14 February 2022

Reference: New Liverpool Primary School SSD-10391 Response to Transport Related Submissions

Drawing Title
SITE PLAN - PART 2

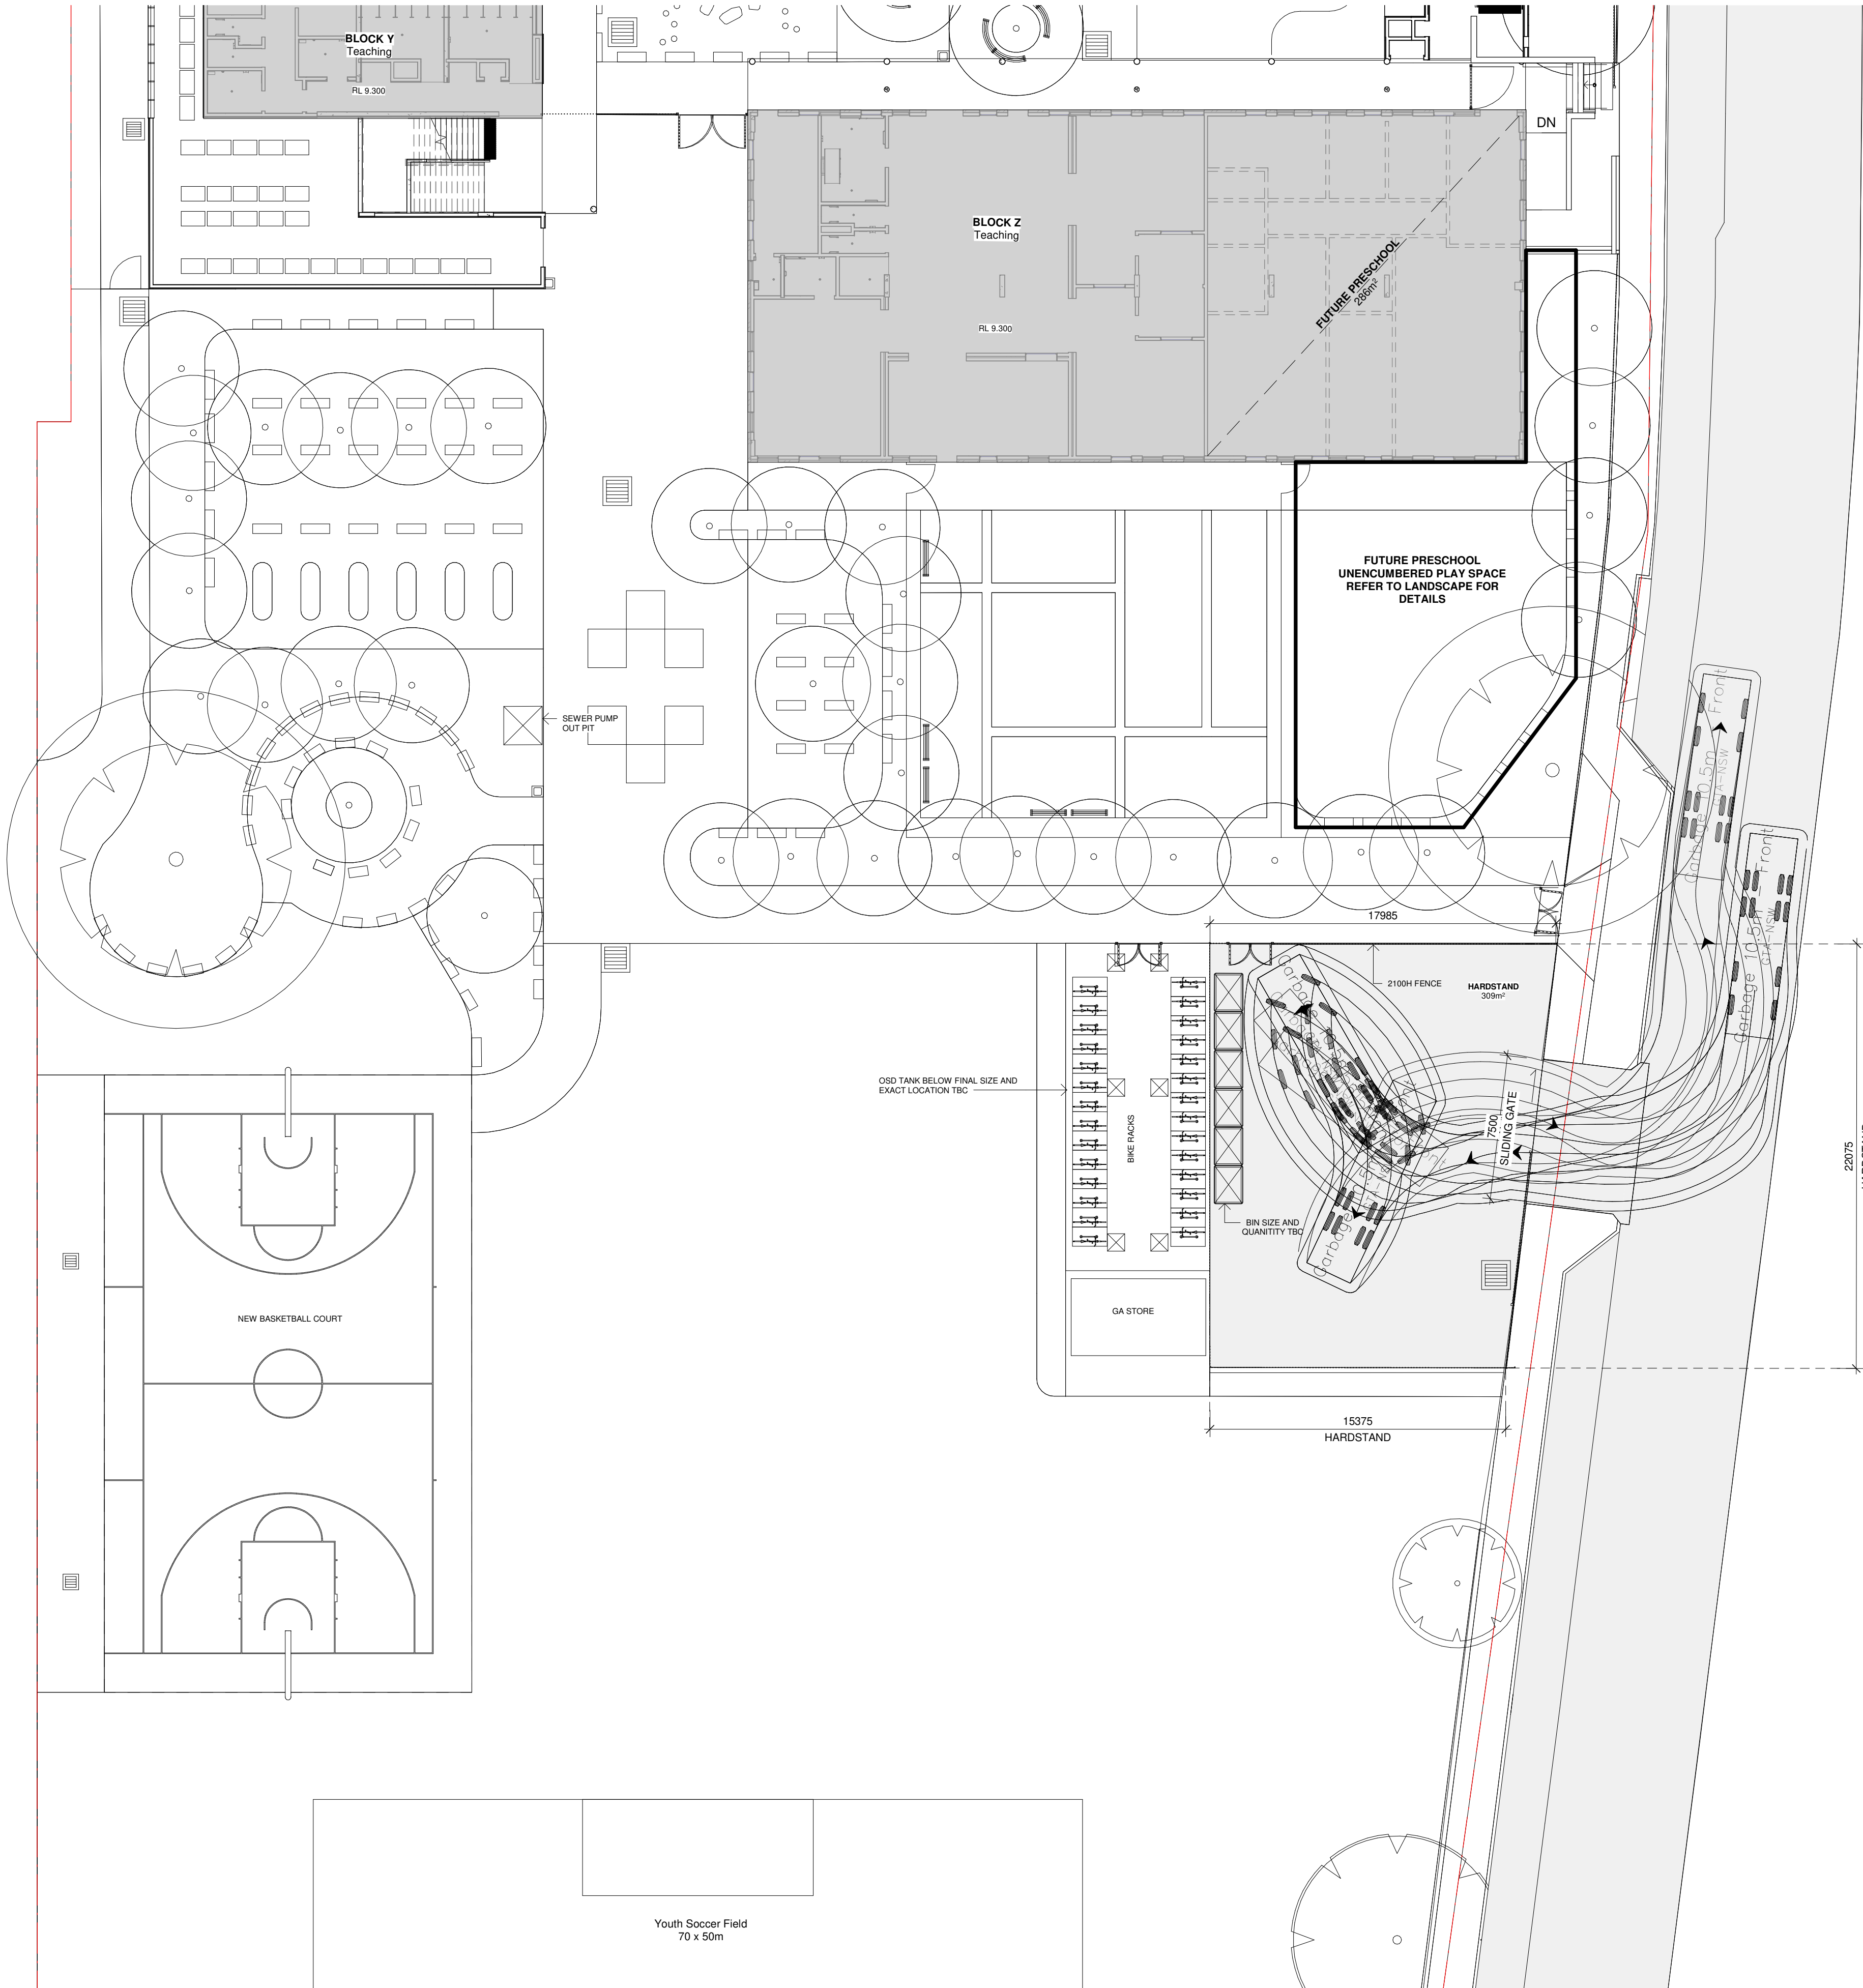
The Department requested additional information regarding parking facility for the preschool users or else an alternate area is to be identified where parents can park during arrival/ departure (when coinciding with the school drop-off/pick-up times). Please address this issue. The response to RFI letter says designated preschool parking spaces of 15mins length of stay will be provided between the hours of 7am to 8:15am and 4pm to 6pm adjacent to the school on Burnside Drive. A detailed study is required for capacity of parking on burnside drive between this time.

To address DPIE's concern regarding the provision of preschool parking spaces, it is proposed that four spaces on Burnside Drive within the school kiss and drop zone be signposted as 15-minute spaces outside of the school zone hours, therefore being from 7am to 8am and 4pm to 6pm. It is also noted that there is currently no parking provision on Burnside Drive and the installation of kerbside parking on the western side of Burnside Drive will be primarily for the school and preschool use. Therefore, preschool use will have access to more than the four designated preschool spaces outside of peak school drop off and pick up.

In addition, to respond to DPIE's request during school drop off and pick up hours, three designated 15-minute preschool on-street parking spaces are proposed on Lachlan Street between the times of 8am-9:30am and 2:30pm-4pm to accommodate preschool drop off and pick up in the event that some preschool demand coincides with the school drop off and pick up times. It is noted that preschool pick up and drop off will be discouraged during these times to assist in reducing traffic congestion around the school at these key busy periods.

Pedestrian paths will be provided connecting the on-street parking spaces on Lachlan Street to the preschool, with the various walking routes shown in Figure 2. These routes equate to a walking distance of approximately 160 metres (through the school site) to 190 metres (along Lachlan Street and Burnside Drive). In Australia the typical walking speed used for determining pedestrian walk time is 1.2 metres per second (Austroads and Transport for NSW), this equates to a walking time of around two minutes
